# Springwell Solar Farm

## Response to Second Written Questions (ExQ2)

Doc. Ref. EN010149/APP/8.26  
Deadline 4  
September 2025  
Springwell Energyfarm Ltd

Arable Weed Management Plan

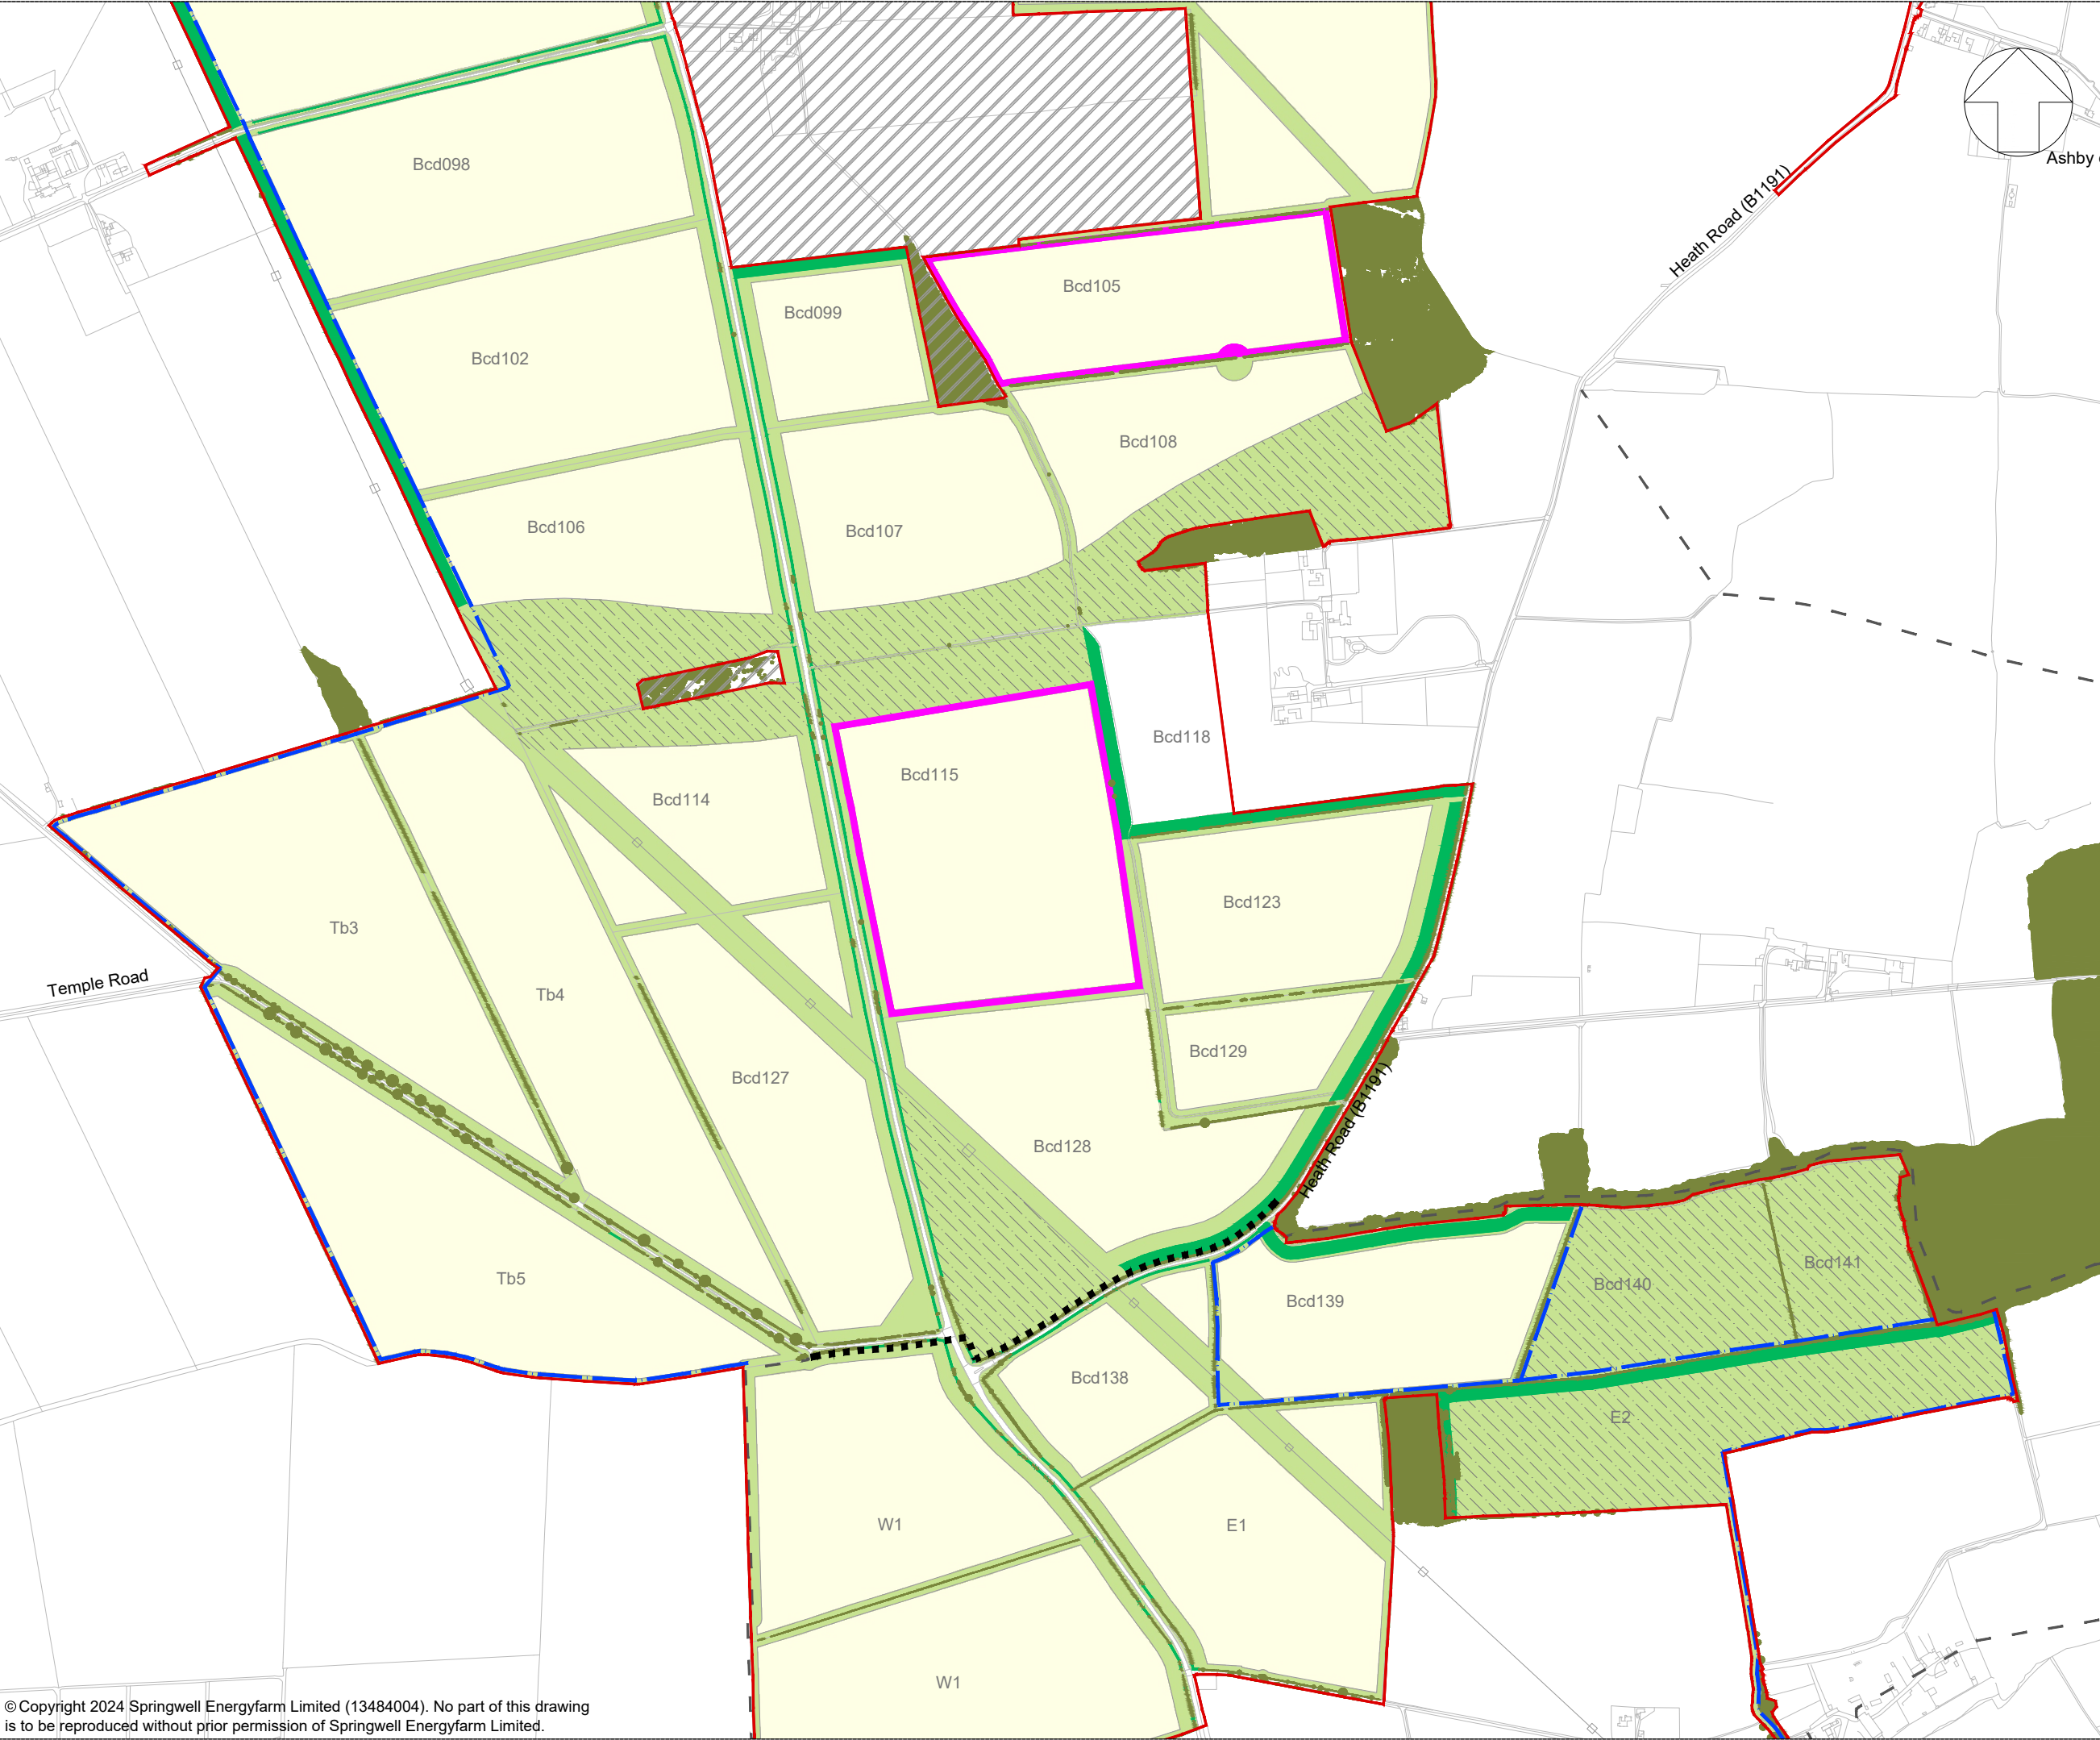
Q2.4.7	<p><b>Scarce Arable Flora</b></p> <p>In Appendix 5 (arable weed management plan) of the oLEMP [REP3-037], the area of grassland managed to benefit arable weeds does not appear to coincide with target note 9 as shown on the arable survey location figures (Figure 2 of [APP-089]). Confirm whether the area of grassland managed to benefit arable weeds in field Bcd115 shown on the arable weed management plan should extend to the north-east corner of the field to include target note location 9.</p>	<p>Appendix 5 of the <b>oLEMP [EN10149/APP/7.9.3]</b> [REP3-037] shows the areas that will subject to management for the benefit of arable weeds and the northern edge of field Bcd115 was shown as being within the area set aside for farmland bird mitigation, this has been updated to include a narrow strip on the east side of field Bcd115 to accommodate the location of the scarce plants indicated by Target Note 9 (Figure 2 of <b>ES Volume 3, Appendix 7.8: Notable Arable Flora Survey [EN10149/APP/6.3]</b> [APP-089]).</p>
